13 February 2021

Re Objection to the West Culburra Concept Proposal – SSD 3846

25405-37

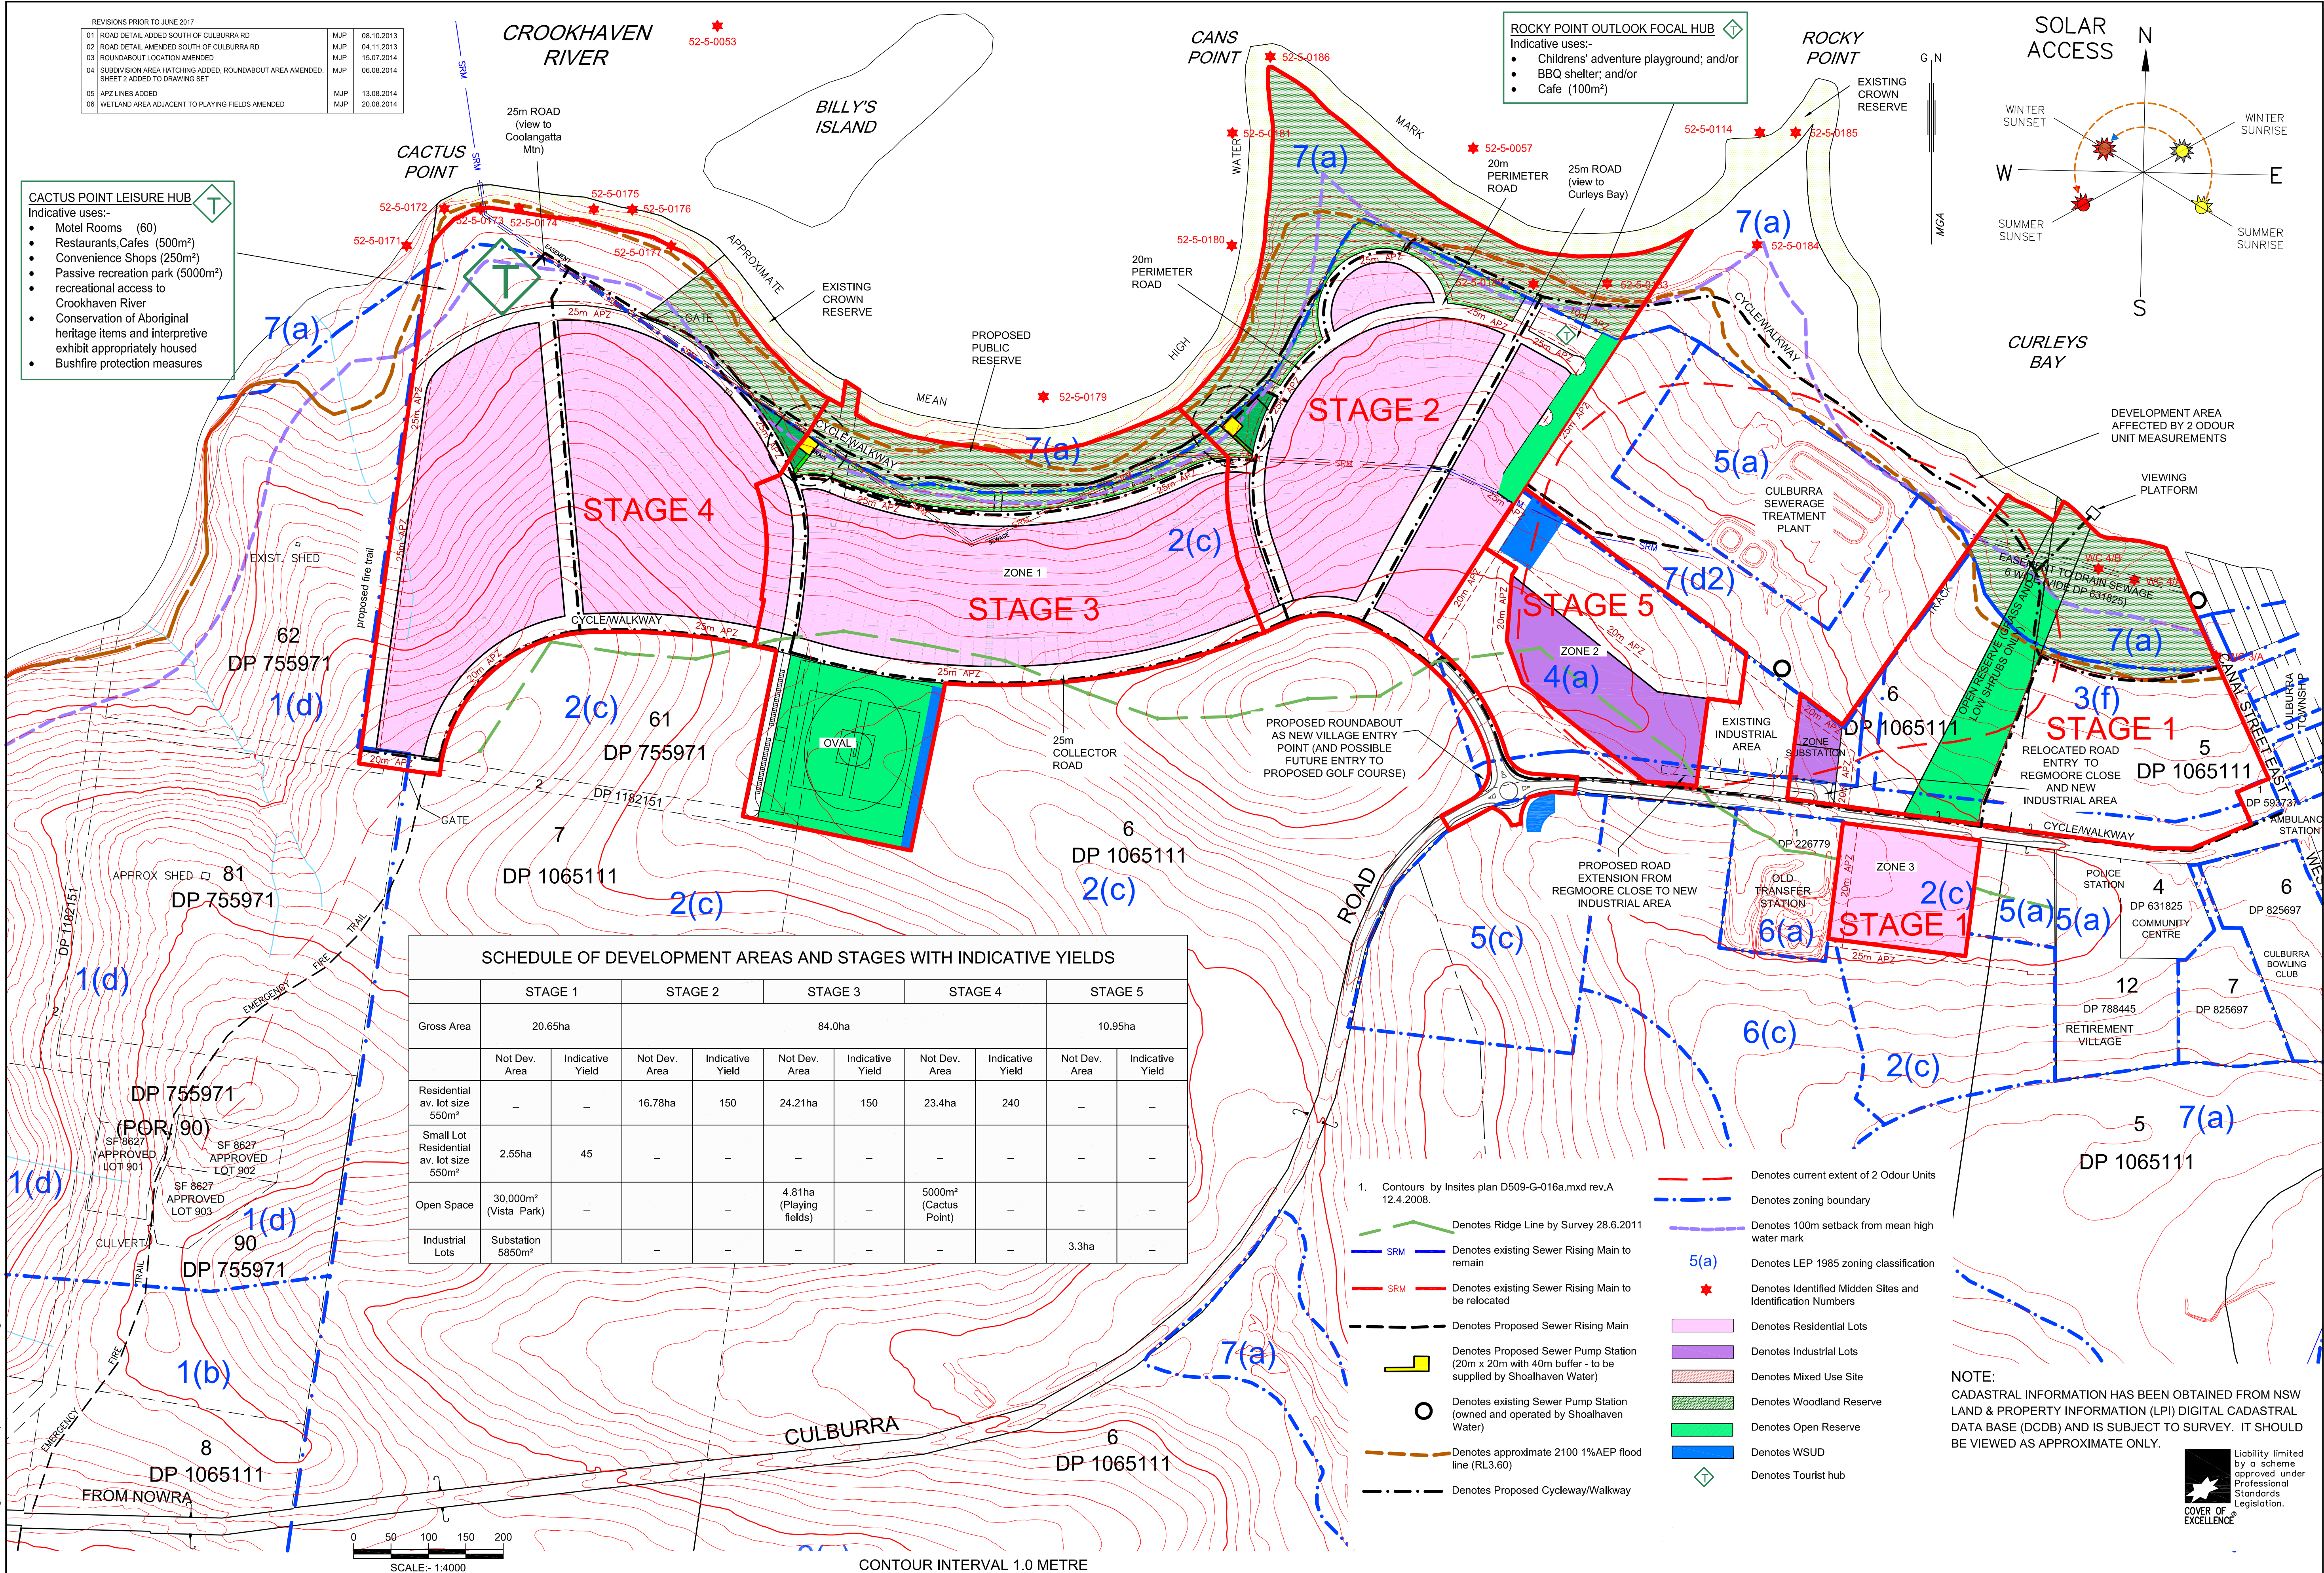
- The boardwalk/cycleway shown will traverse through wetlands in an E2 zone. This option is not required when there is an existing car width track that could be upgraded behind the STP that would not require clearing or interfering at all with the wetland vegetation or mangroves.

- The scale and dimensions of the Industrial units is over-kill in my opinion and not justified. I don't believe it would be competitive with Nowra/Bomaderry which is the main Industrial hub with good access to transport links, Princes Highway and the railway. The smaller Industrial lot to the east of the existing industrial area is in my view a better option for extending the existing industrial area.

- I strongly object to the proposed HOB change from the existing 7.5m to 11m described as Medium Density. As Matt Philpott of Allan Price & Scarrats said in his recent presentation, "the 12 large blocks will be sold to a builder and is zoned for High-rise flats" - not Medium density. There are no drawings provided to show how a wall of 11m tall buildings would look along the main road into Culburra Beach. Totally out of character.

- There is no provision for playgrounds and community spaces outside of the odour zone in this medium density section of the concept plan.
- The medium density area integrates well with the existing township. The area to the west of STP is not connected to the existing town but separated by bushland, the STP and industrial estate. Residents will need to drive to do their weekly shop. It would be a satellite to the existing township.

- Culburra Beach does not need another playing field. The existing playfields have been upgraded over the years and I believe application was made to Council to extend or upgrade them further. I understand that the playing fields have been included mainly to dispose of stormwater. If that is the case then I think the playing fields are a waste of space, particularly given that it is inside the odour zone which will likely impact on team sports participants and spectators. It would be most unpleasant. It would be better left untouched as scribbly gum forest and wetland providing more of a buffer to the STP.
